Addendum No. 2

RE: Contract # C204397

Rutherford County (R-2233BB)

US-221 SOUTH OF US-74 BUS (CHARLOTTE RD) TO NORTH OF SR-1366
(ROPER LOOP RD).

PROJECT REFERENCE NO. R-2233BB	SHEET NO. 52
ROADWAY DESIGN ENGINEER 	HYDRAULICS ENGINEER

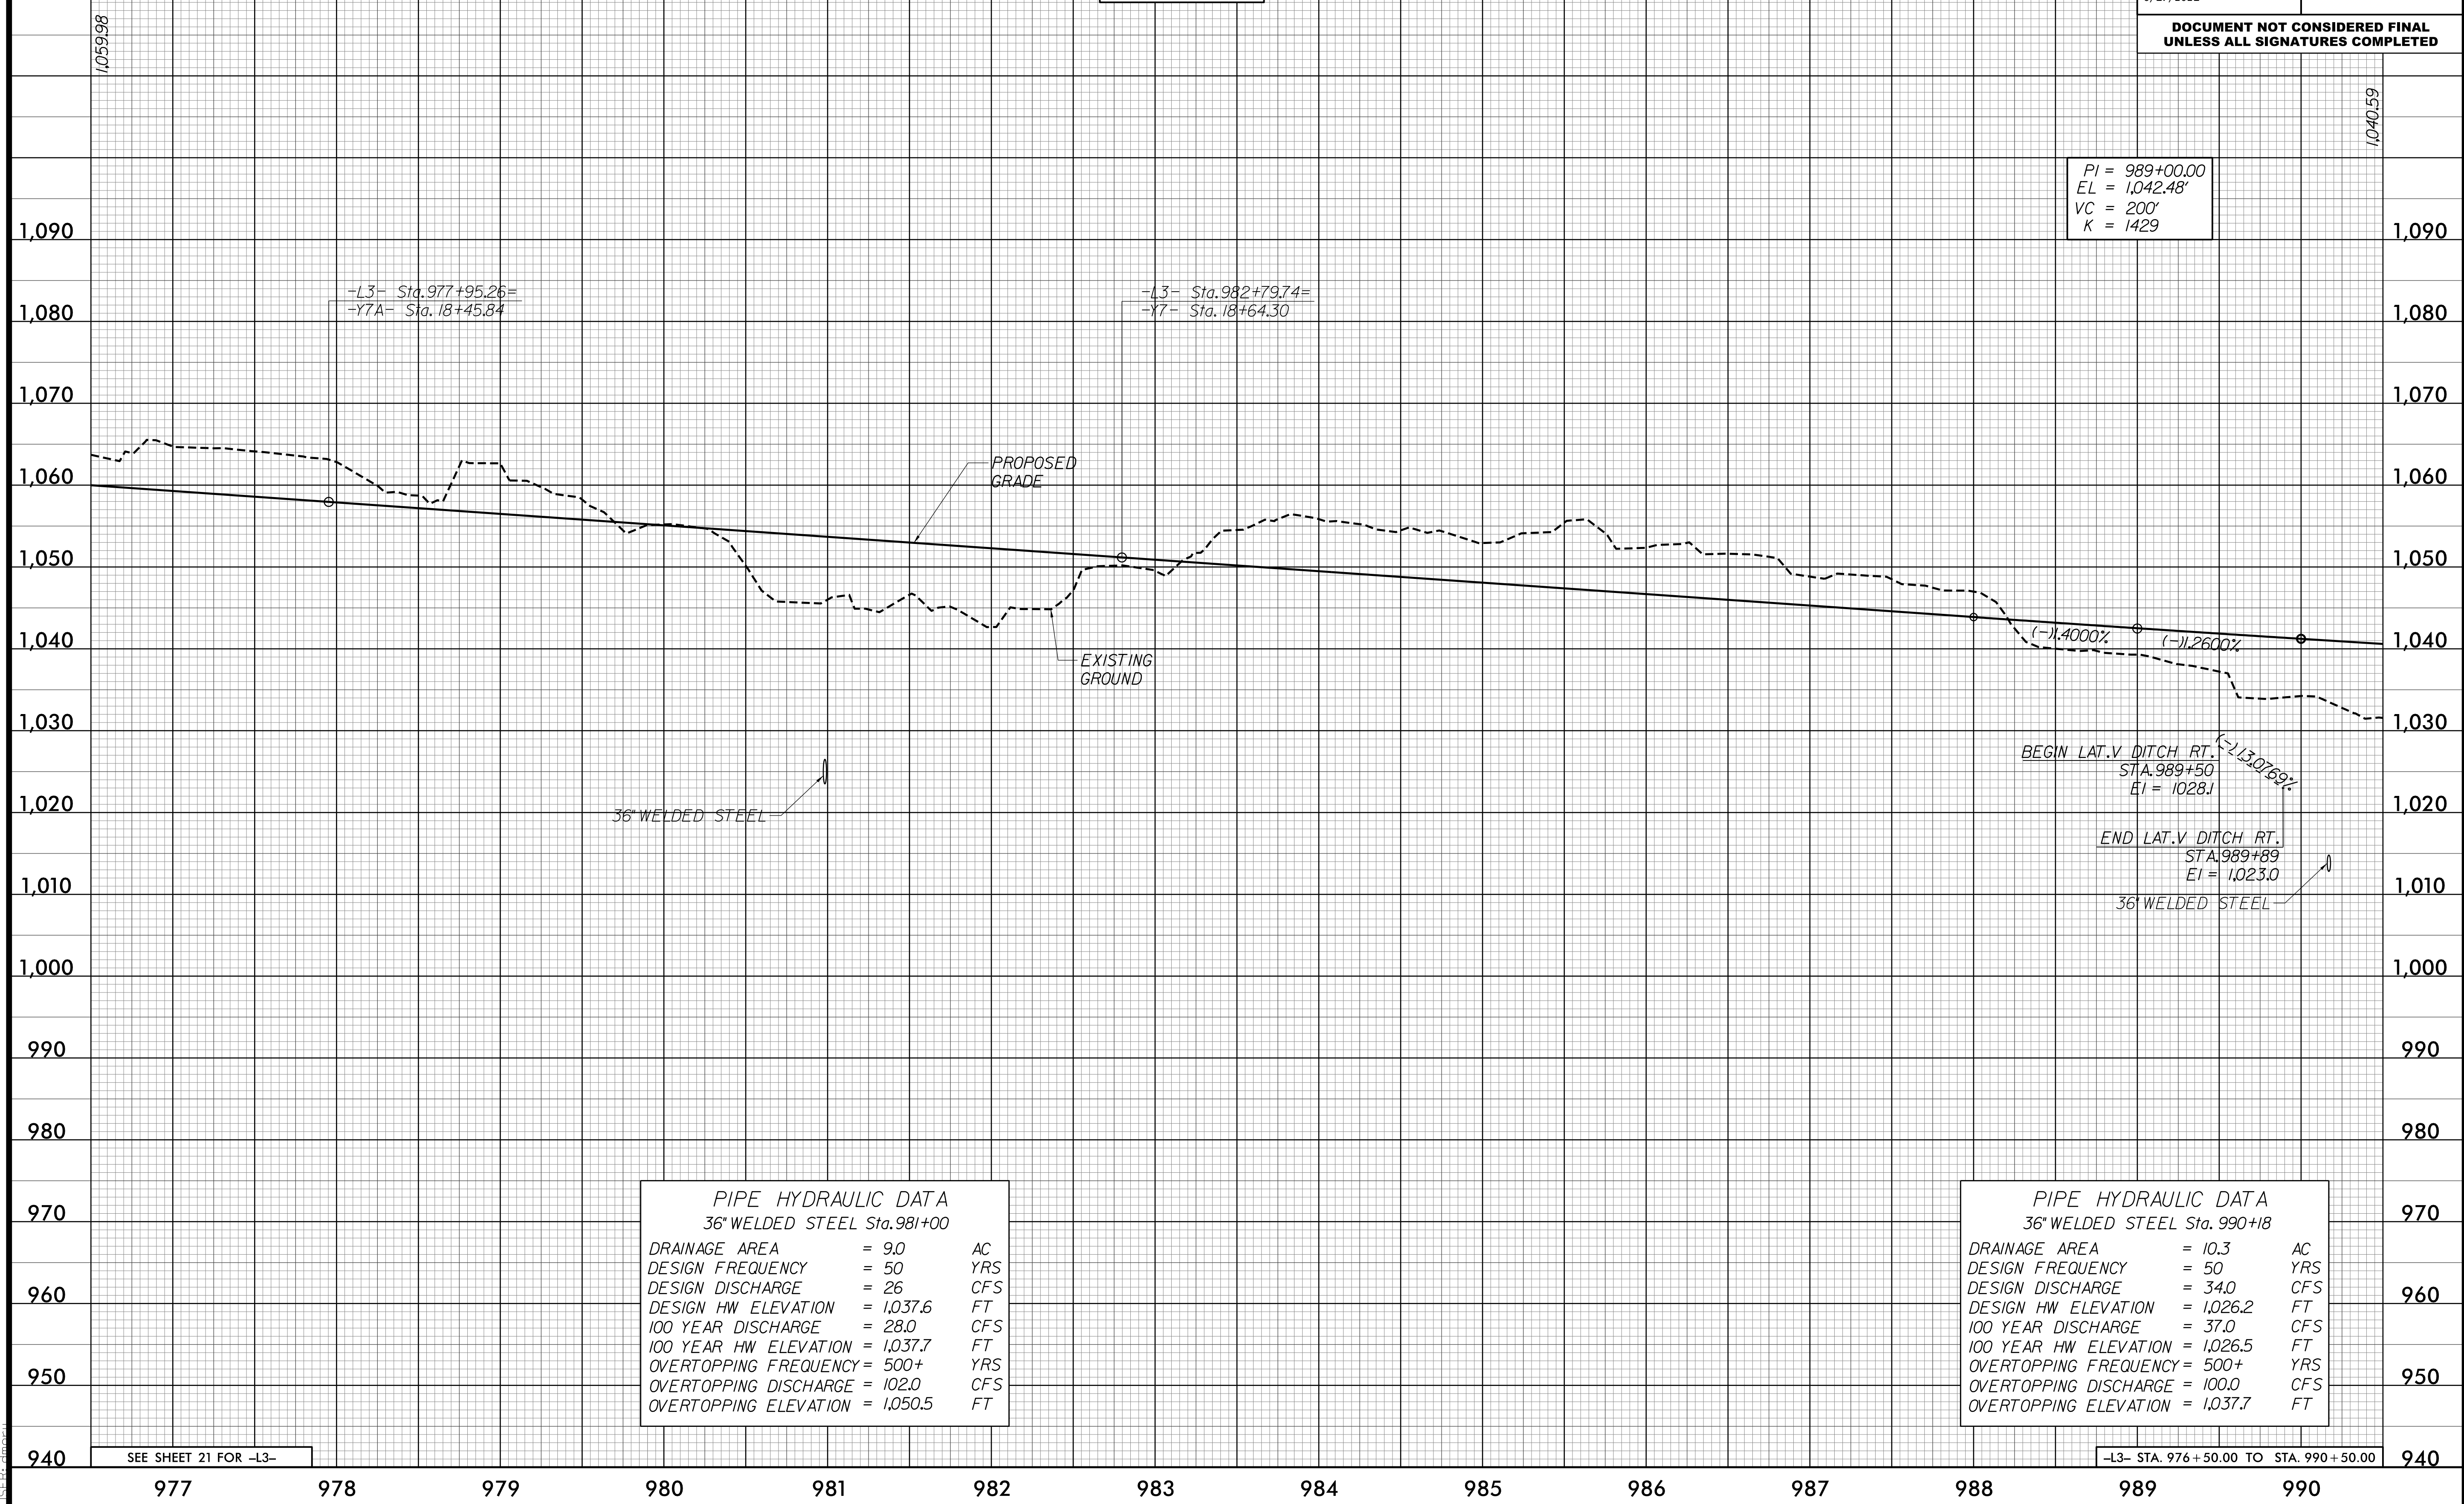
<u>Item</u>	<u>Description</u>	<u>Old Quantity</u>	<u>New Quantity</u>
0052-0973100000-E-330	42" WELDED STEEL PIPE, 0.625" THICK, GRADE B IN SOIL	552 LF	276 LF

0053-0973100000-E-330	66" WELDED STEEL PIPE, 0.875" THICK, GRADE B IN SOIL	244 LF	122 LF
0054-0973300000-E-330	36" WELDED STEEL PIPE, 0.500" THICK, GRADE B NOT IN SOIL	692 LF	346 LF
0398-0973100000-E-330	36" WELDED STEEL PIPE, 0.500" THICK, GRADE B IN SOIL	NEW ITEM	346 LF
0399-0973300000-E-330	42" WELDED STEEL PIPE, 0.625" THICK, GRADE B NOT IN SOIL	NEW ITEM	276 LF
0400-0973300000-E-330	66" WELDED STEEL PIPE, 0.875" THICK, GRADE B NOT IN SOIL	NEW ITEM	122 LF
0401-3575000000-E-SP	ORNAMENTAL WOOD FENCE	NEW ITEM	100 LF
